OUFC Planning Application Ref: 24/00539/F

Ecology / Biodiversity Net Gain

Objection

From: Friends of Stratfield Brake (FoSB)

**FIGURE 8.2**

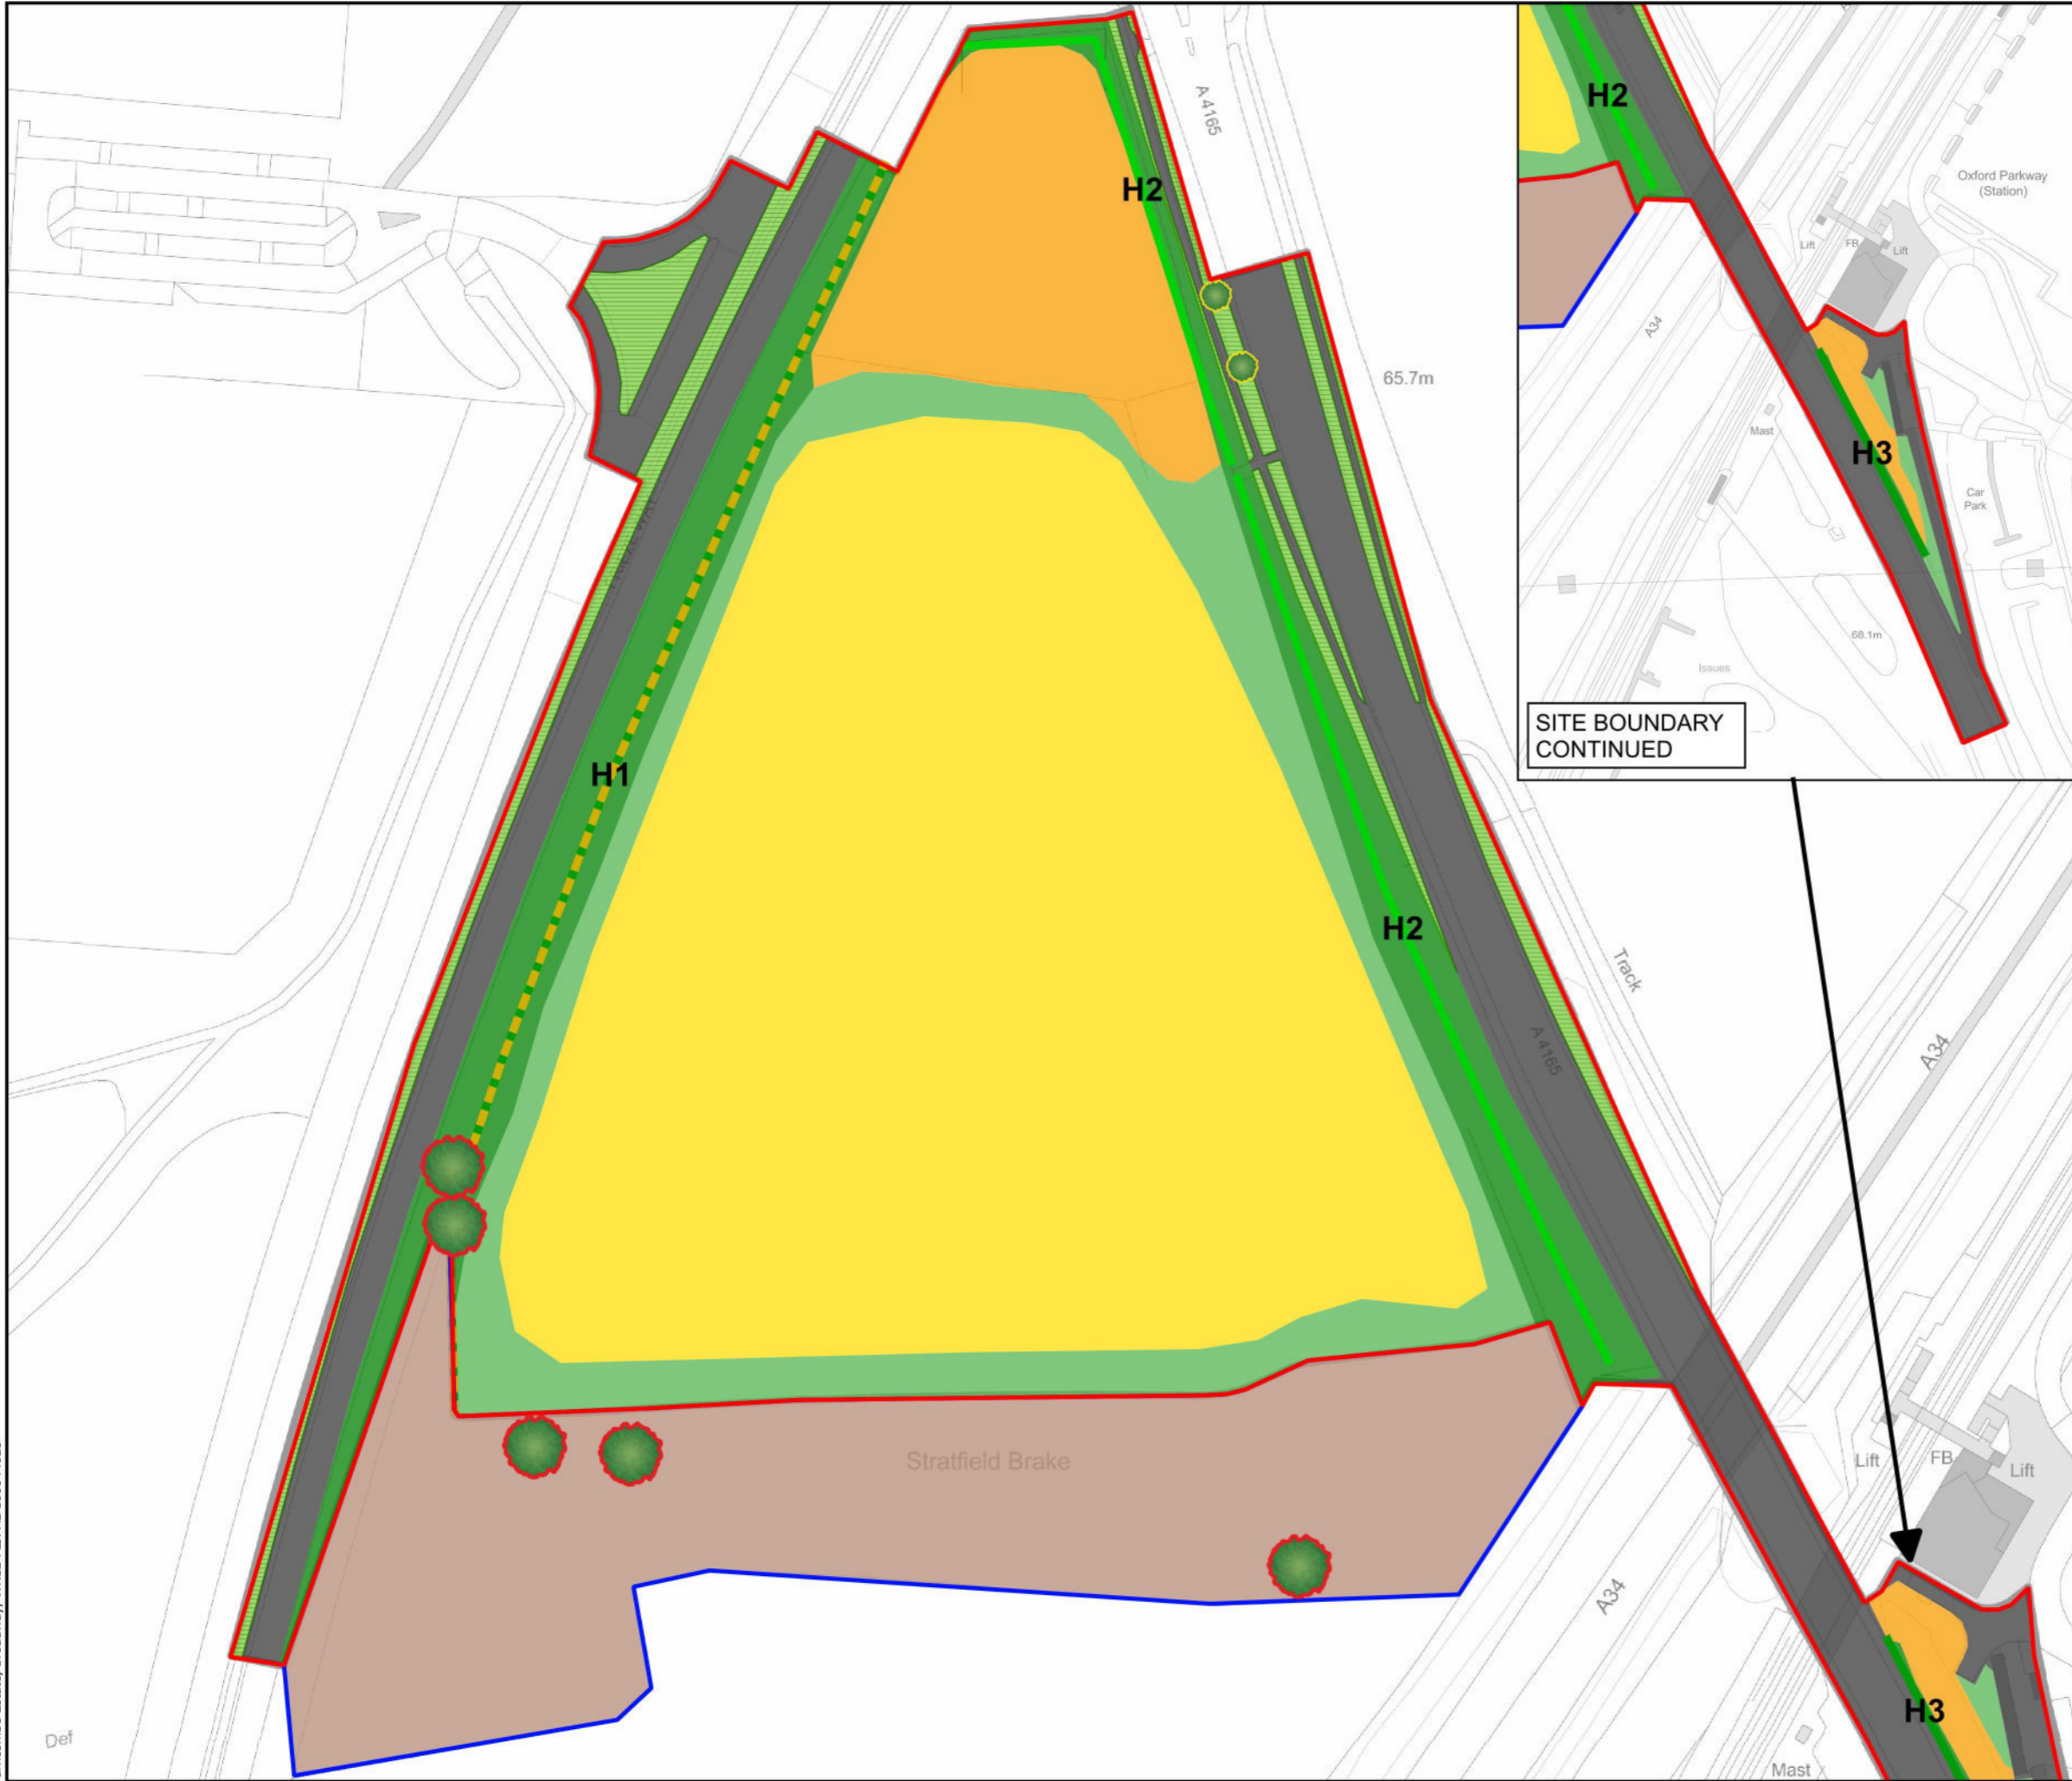
12. The woodland's valuable habitat is not sufficiently recognised by the Aboricultural Report. It is important that no deadwood is removed.
13. Bats, including rare species such as Barbastelle, use the site, particularly the southern area by the woodland. This woodland contains many bat roosting opportunities. According to our independent ecologist's report these are more numerous than those recorded by Ecology Solutions (Fig 8.2 ES Volume 3 Technical Appendix 8.1).
